TfNSW reference: REN 25/00096/004

SSD-63207219, Kingswood Battery Energy Storage System, 744 Burgmanns Lane, Kingswood 2340; Request for Additional Information Letters 22 and 23 May 2025, Updated Traffic Impact Assessment August 2025.

TfNSW has reviewed the updated Traffic Impact Assessment prepared by Arcadis dated 05 September 2025 and has provided the outstanding matters in **Attachment A**.

Figure 3-2: OSOM route proposed in the TIA (Update) (October 2025) (Source: NVHR Route Planner Tool) – Option 1

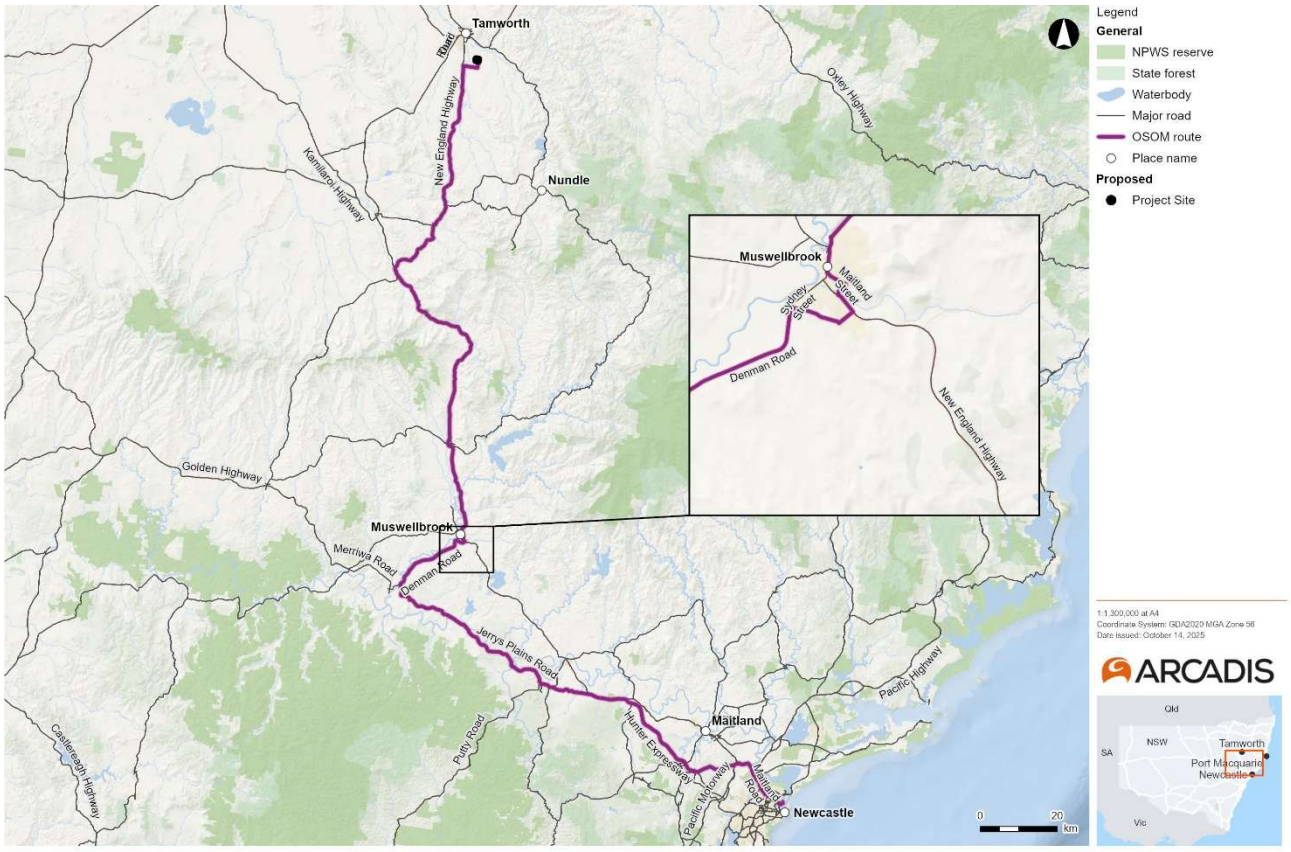
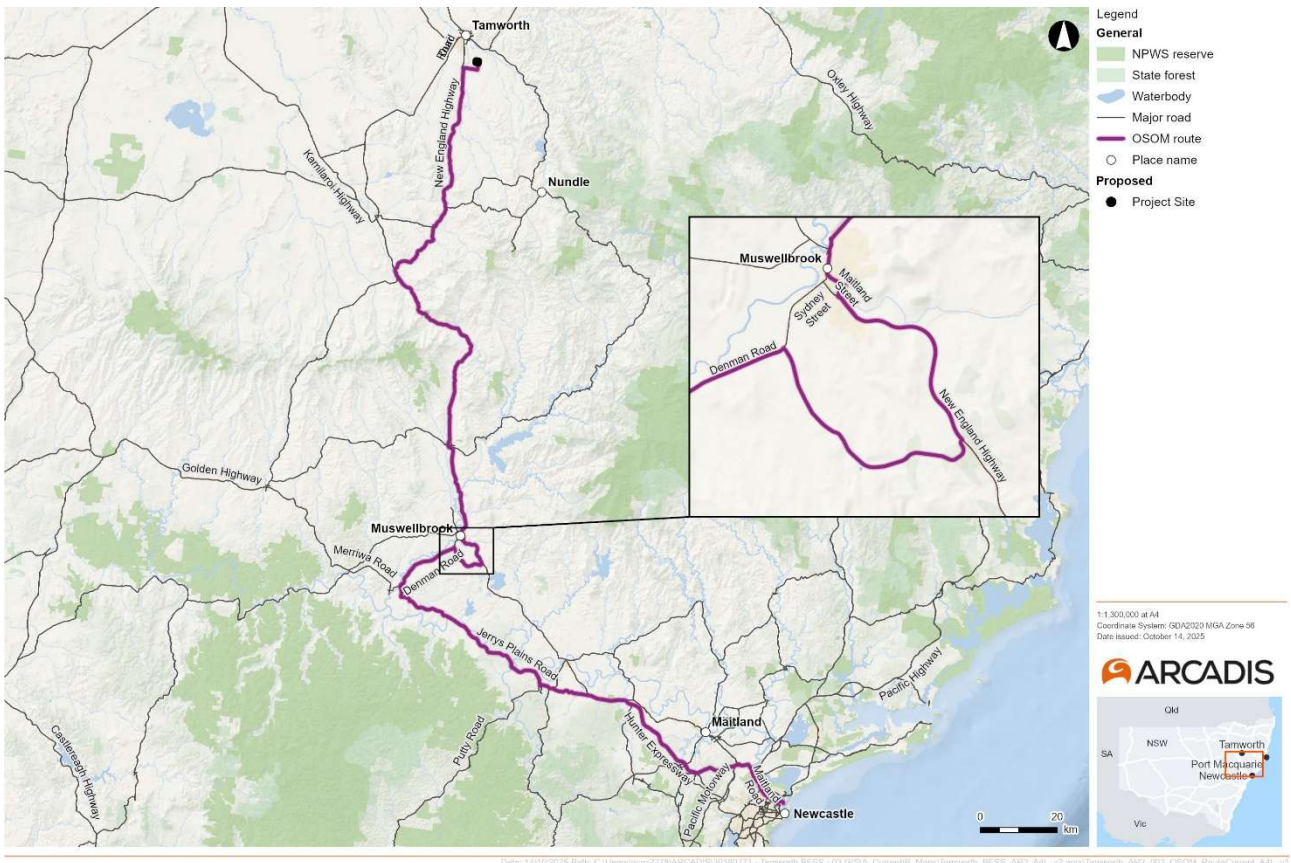
b) Section 3.5.1.2 has been included within the revised TIA to address point 5(b) of TfNSW previous additional information request. Section 3.5.1.2 advises that the size and number of OSOM vehicles will be confirmed during the construction phase and included in the Construction Traffic Management Plan. TfNSW advises that the dimensions of high-risk OSOM-laden loads (heights, lengths, and widths) and weights should be identified, and a route analysis should be completed before determining the project.	PARTIALLY CLOSED TfNSW has reviewed the updated swept path assessment in Appendix D in the TIA report which shows temporary pavement at the Market Street roundabout; adjustments to the kerbing and traffic island are required. S138 Concurrence from TfNSW and Consent from Council will be required for any proposed changes and at that point detailed designs must be submitted in accordance with TfNSW/Council specifications and include the following. • Details on how the modifications to the central island will integrate with the existing infrastructure, the splitter island kerb profiles, and the existing drainage inlet (considering vehicle loadings), as well as how the modifications to the central island will integrate with the existing infrastructure. • Temporary changes to state road assets will need to include the length of time they will be affected, any interim treatments (e.g., line marking), and when and what will replace the asset post-completion of high-risk OSOM movement • Signs/light poles maybe required to be removed. Details on any temporary signage and the timeframe for replacing traffic signs are to be included. TfNSW request the TIA be updated to reflect the above

c) The route assessment will consider current projects along the road network, including the Newcastle Inner City Bypass (which is required to be used to avoid the Hexham Straight works for high-risk OSOM up to a height of 5.25m) and Singleton Bypass project at the New England Highway, resulting in a height restriction of 5.4m	CLOSED Current projects are considered in the route assessment summarized in Section 4.3 in the TIA report. No further action required.

Figure 1 – New England Highway / Burgmanns Lane upgrade

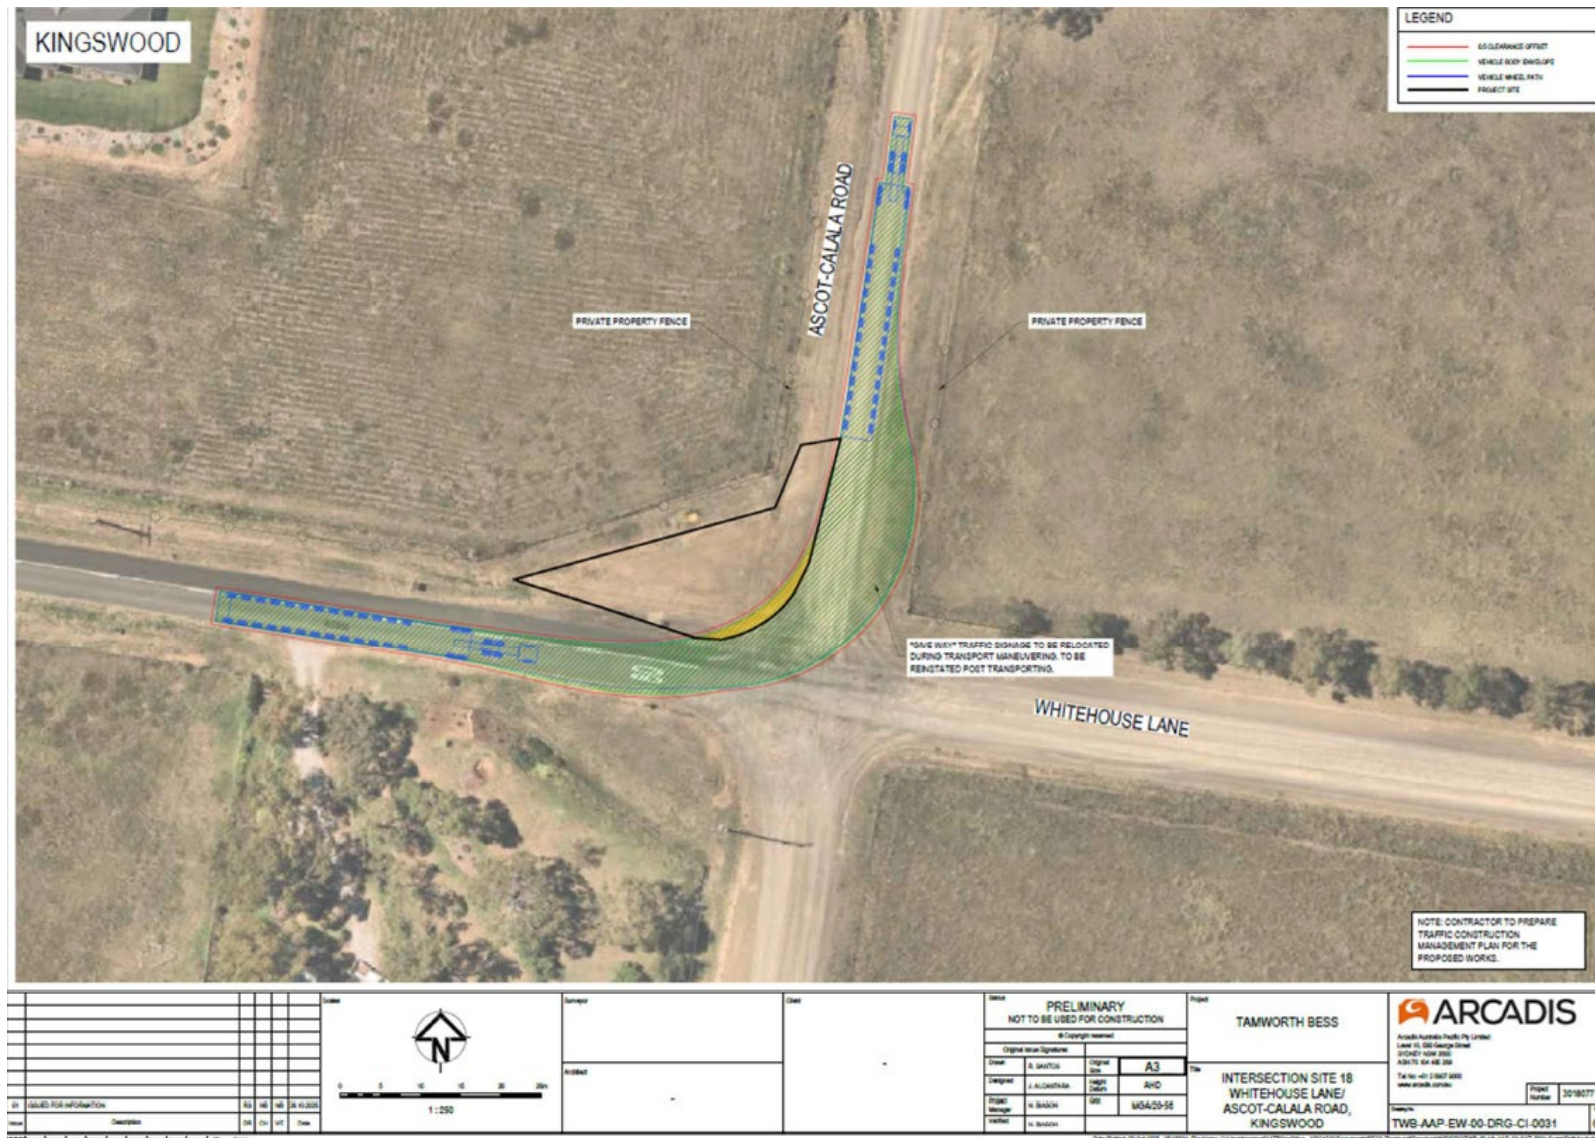
TfNSW's Previous Comments dated 23 May 2025	TfNSW additional information requested
Existing intersection treatments for both traffic at Burgmanns Lane/New England Highway intersections and Whitehouse Lane/New England Highway	
1 (b) Provide a strategic concept design to increase the length of the CHR(S) to a compliant CHR for the New England Highway/Whitehouse Lane intersection and provide a strategic concept design to increase the length of the AUL(S) to a compliant AUL for the left turn treatment at New England Highway/Burgmanns Lane. OSOM Route Assessment Requirements	OPEN The TIA and Strategic concept designs must be revised for intersection and the Whitehouse Lane/New England Highway intersection to address the following. 1. Incorporate a notation on the plans at the intersection of Whitehouse Lane/New England Highway which highlights the need to address the structural capacity of shoulder pavement and upgrade to suitable shoulder material if required. 2. Incorporate a notation on the plans at the intersection of Whitehouse Lane/New England Highway which highlights shoulder widening to be provided to reinstate the width used to facilitate the now south bound lane edge line.
